OXFORDSHIRE COUNTY COUNCIL'S RESPONSE TO CONSULTATION ON THE FOLLOWING DEVELOPMENT PROPOSAL

Application no: 21/01630/OUT

Proposal: Outline planning application for residential development (within Use Class C3), open space provision, access, drainage and all associated works and operations including but not limited to demolition, earthworks, and engineering operations, with the details of appearance, landscaping, layout and scale reserved for later determination

Date: 14 July 2021

DRAWING TITLE  
**PROPOSED PEDESTRIAN CROSSING TO CHURCH**

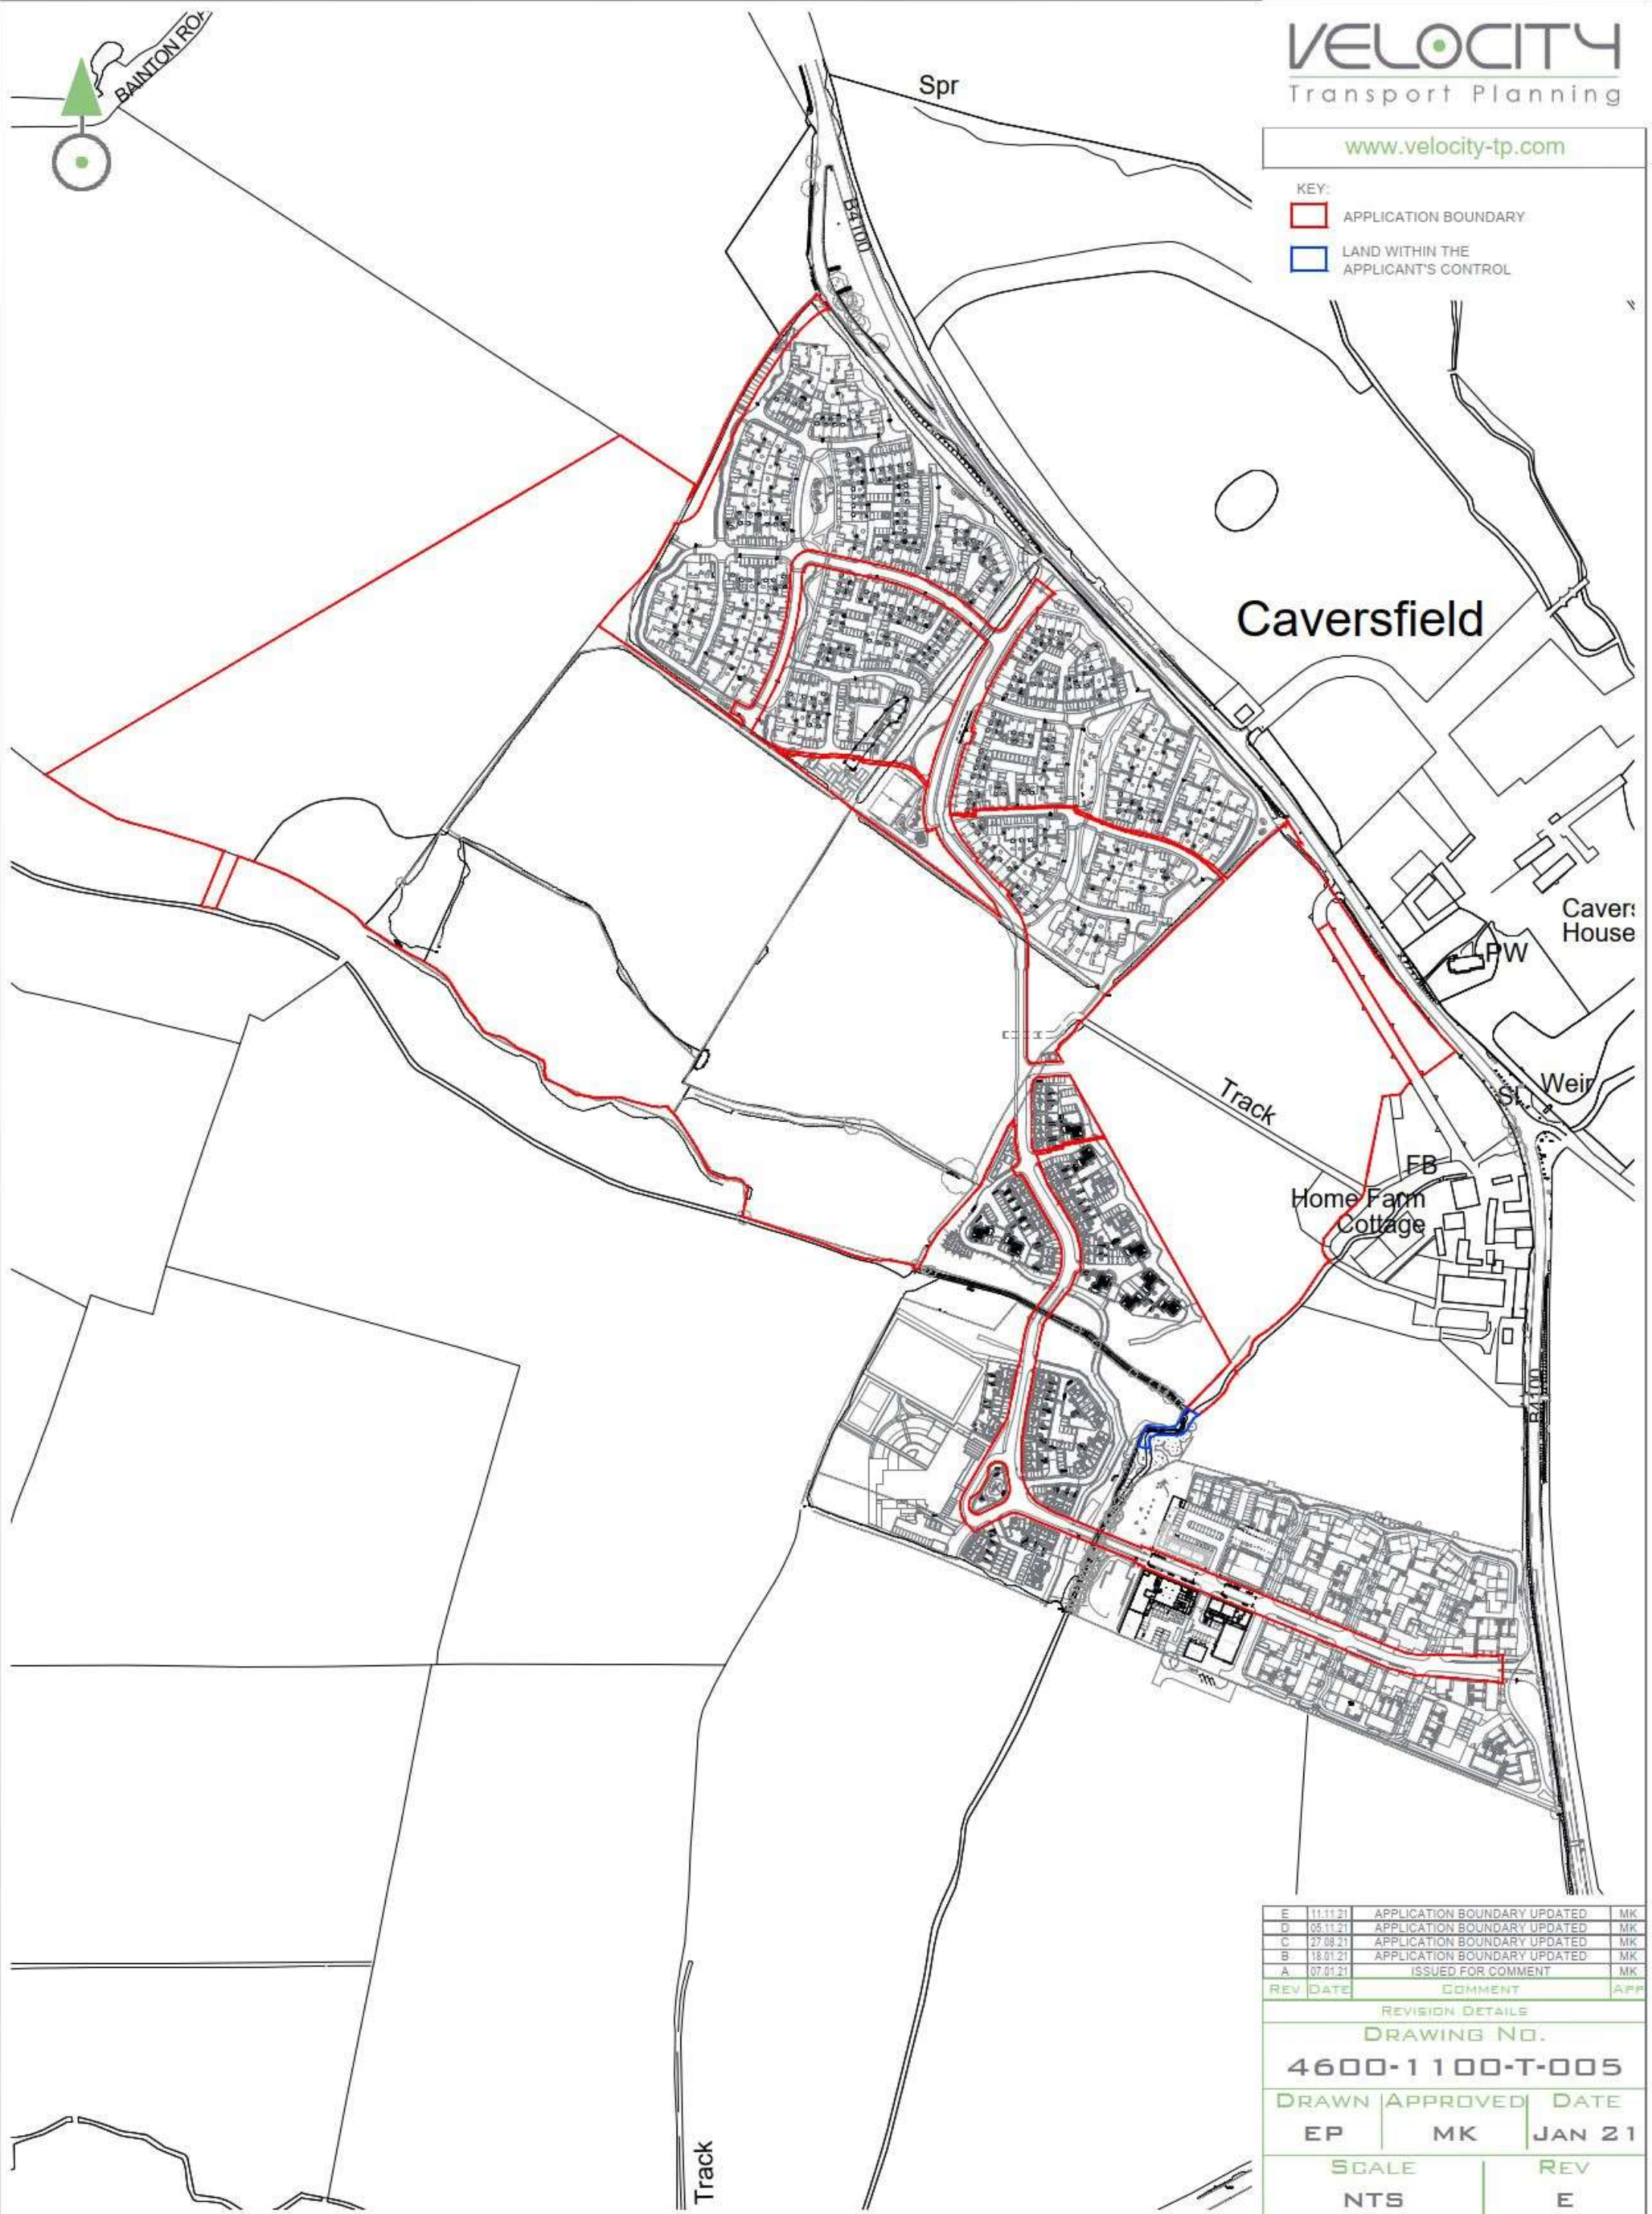
I note the application makes no commitment to provide a pedestrian crossing on the B4100 to allow residents to access Caversfield Church. This will be the local place of worship for the allocation, there being no other place of worship in the NW Bicester masterplan, and will therefore be a need for a safe crossing. A signalised crossing was requested in relation to the previous planning application on the eastern parcel, to be implemented by the developer under S278. **Reason for objection**

DRAWING TITLE  
**SITE ACCESS D  
 DIRECT ACCESS TO NORTH OF THE WESTERN PARCEL**

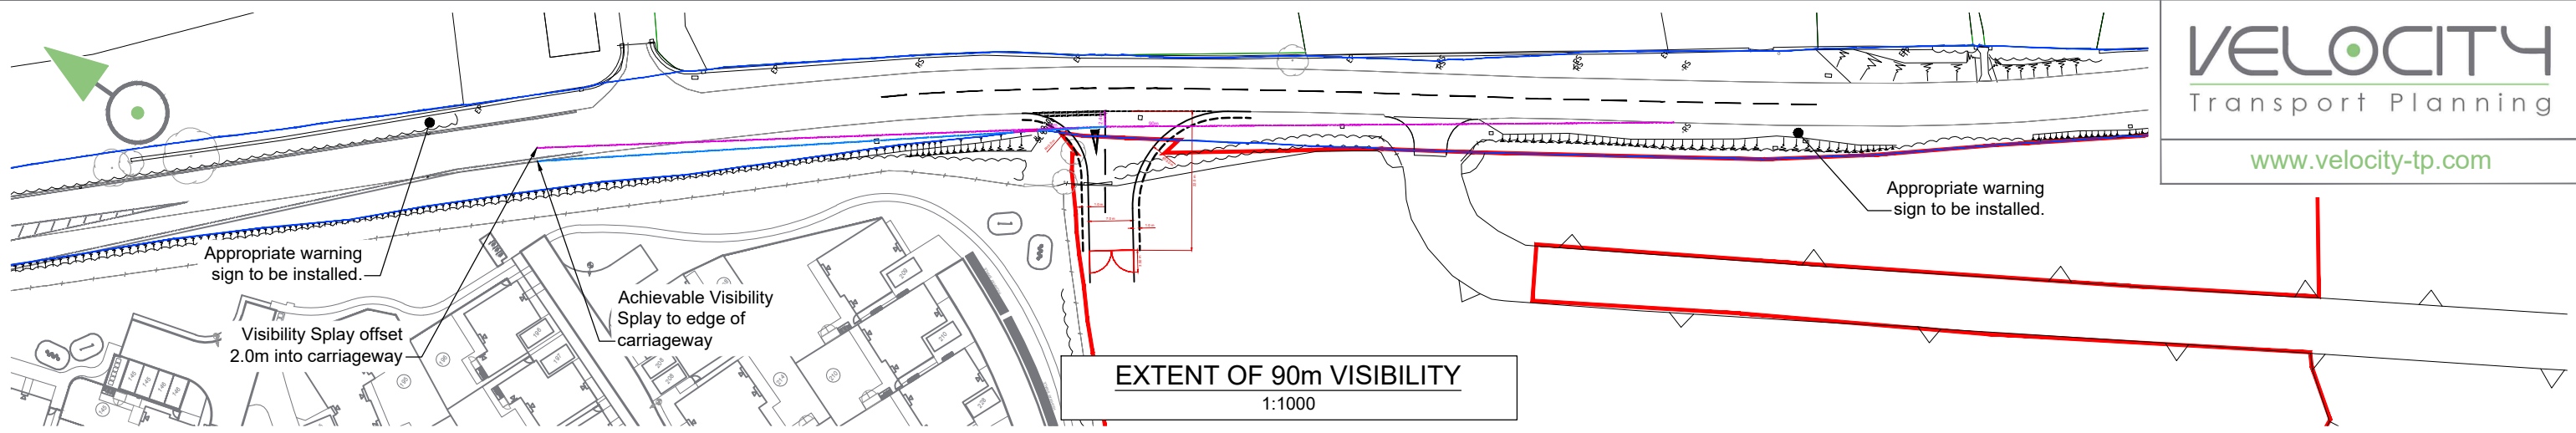
Access D leads directly into the road network of the existing Elmsbrook development. Swept path analysis should be provided of this entire route, showing car passing refuse vehicle, to show that it is suitable for connection to 200+ further dwellings. This access should have a 2m footway on both sides. **Further information required.**

**CONSTRUCTION ACCESS - SWEEP PATH ANALYSIS**  
1:250

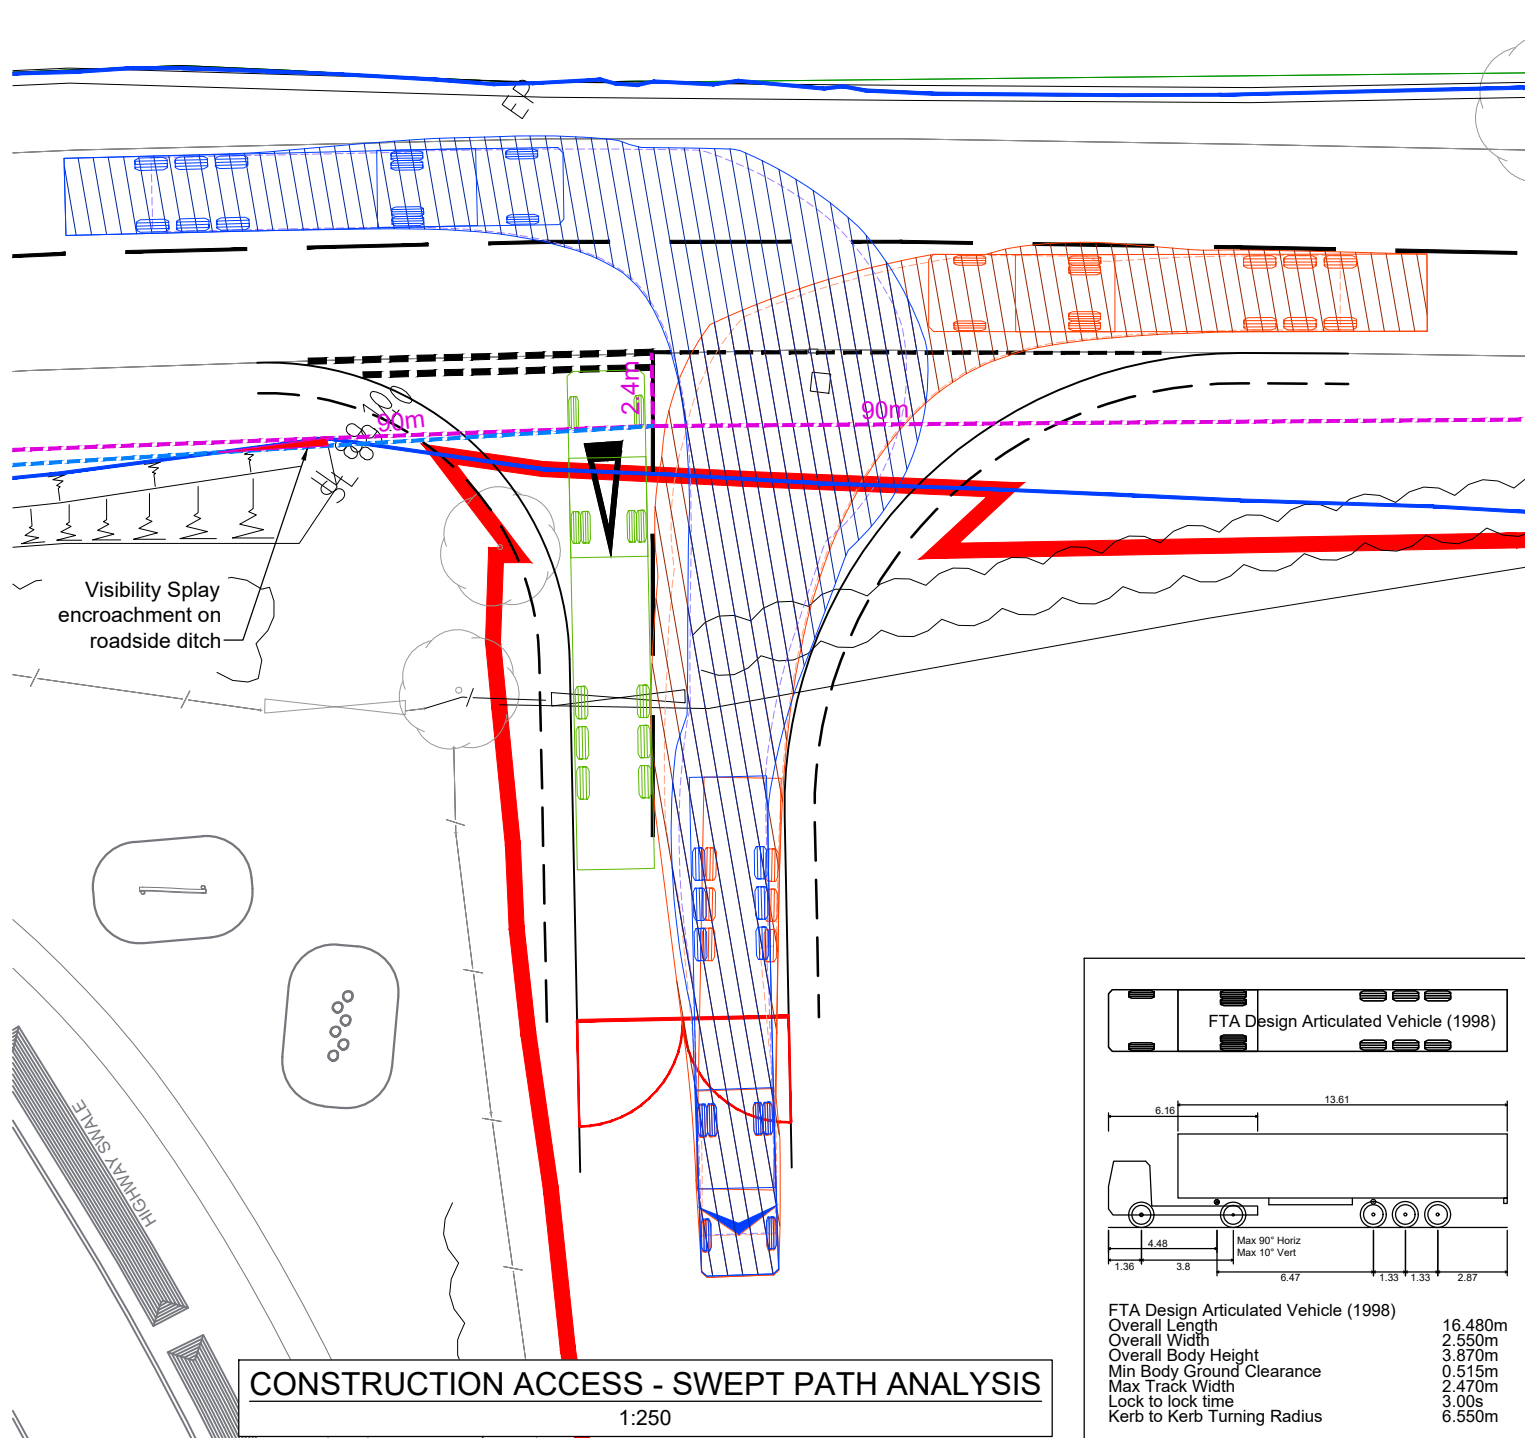
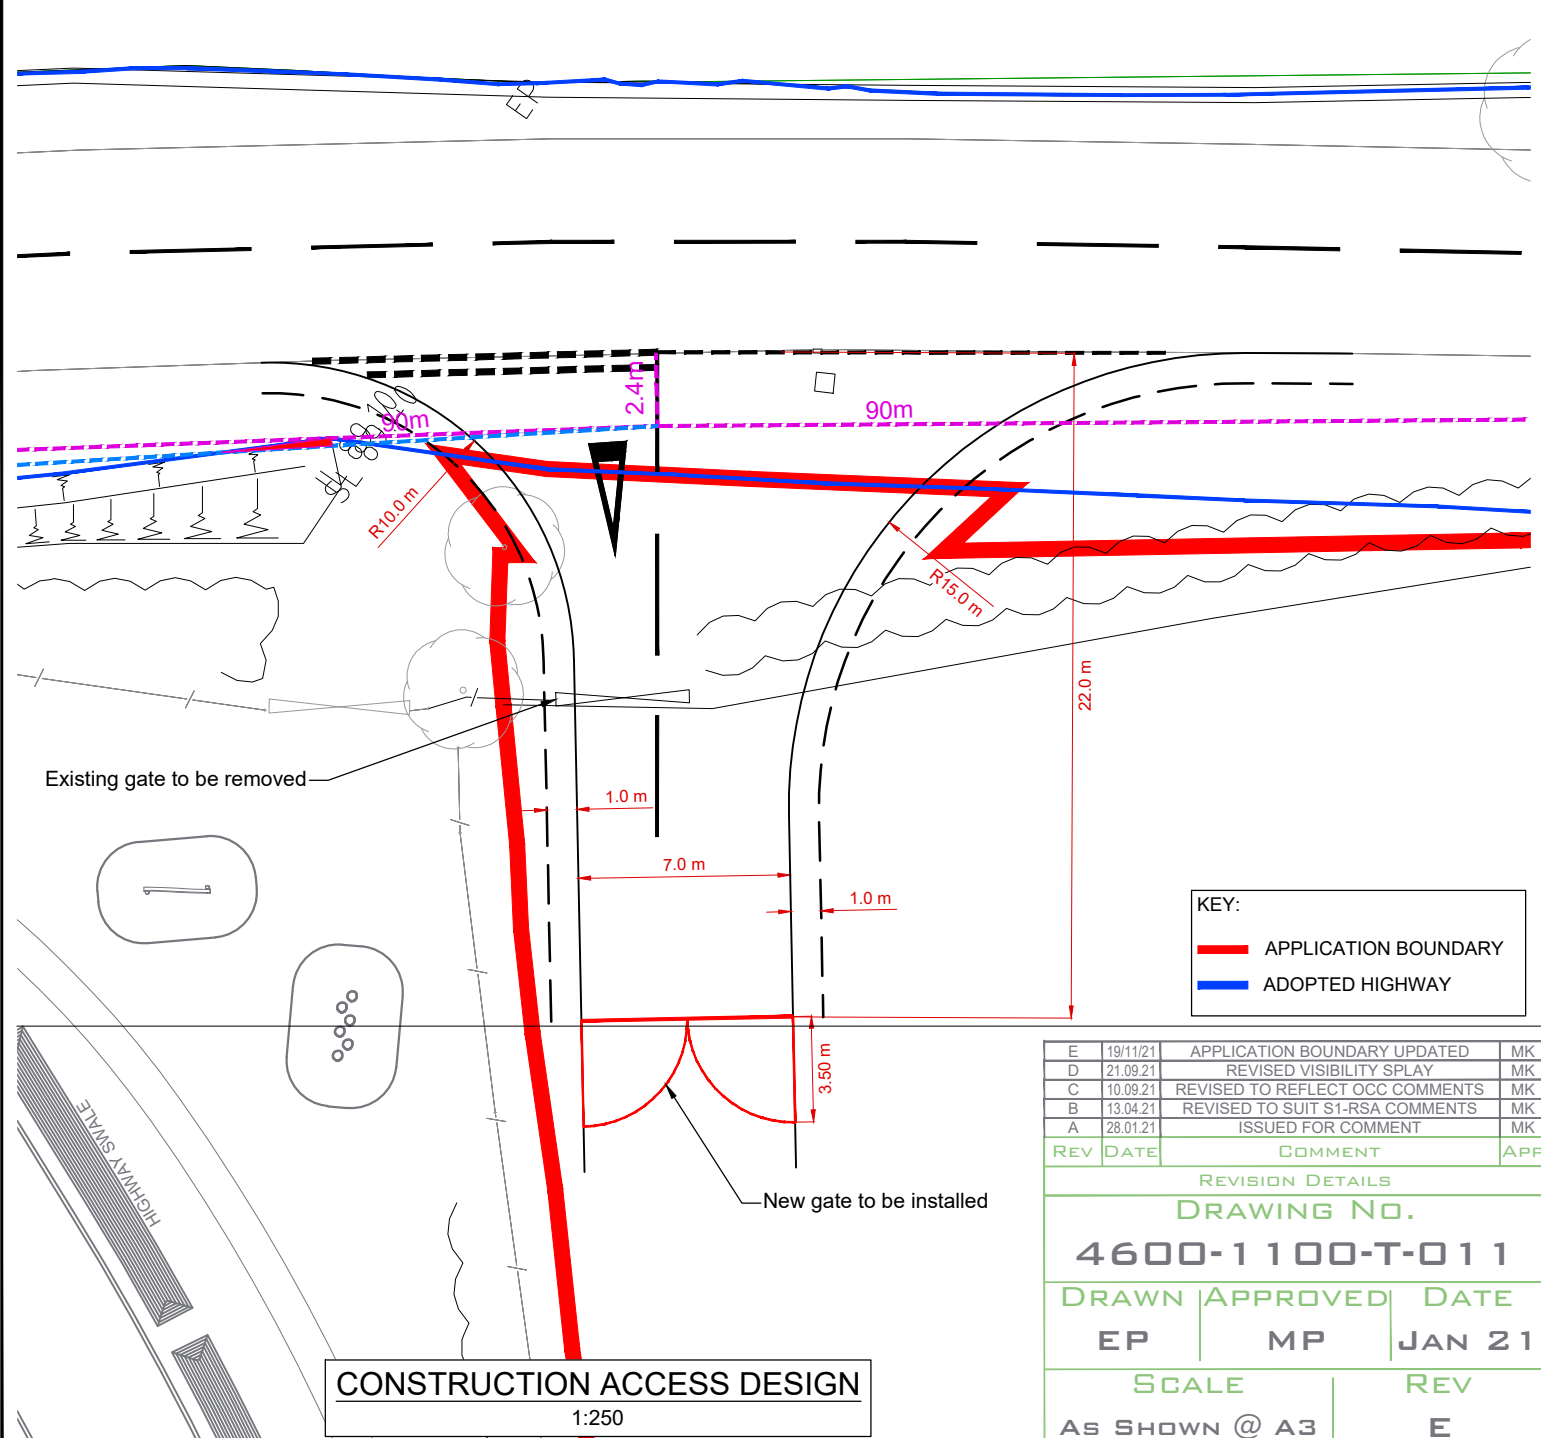
Permission is also sought for a construction access into the eastern parcel directly off the B4100 in the approximate position of an existing field access. The construction of this access will require a S278 agreement. I have no objection to this access in principle, provided adequate visibility can be provided. However, I note that the necessary visibility splay to the north crosses a ditch that is not within the highway boundary. The applicant would need to obtain title to this land for the purposes of the S278 agreement and it can't be assumed this is possible. The visibility splay does not appear to be within the red line. **Reason for objection**
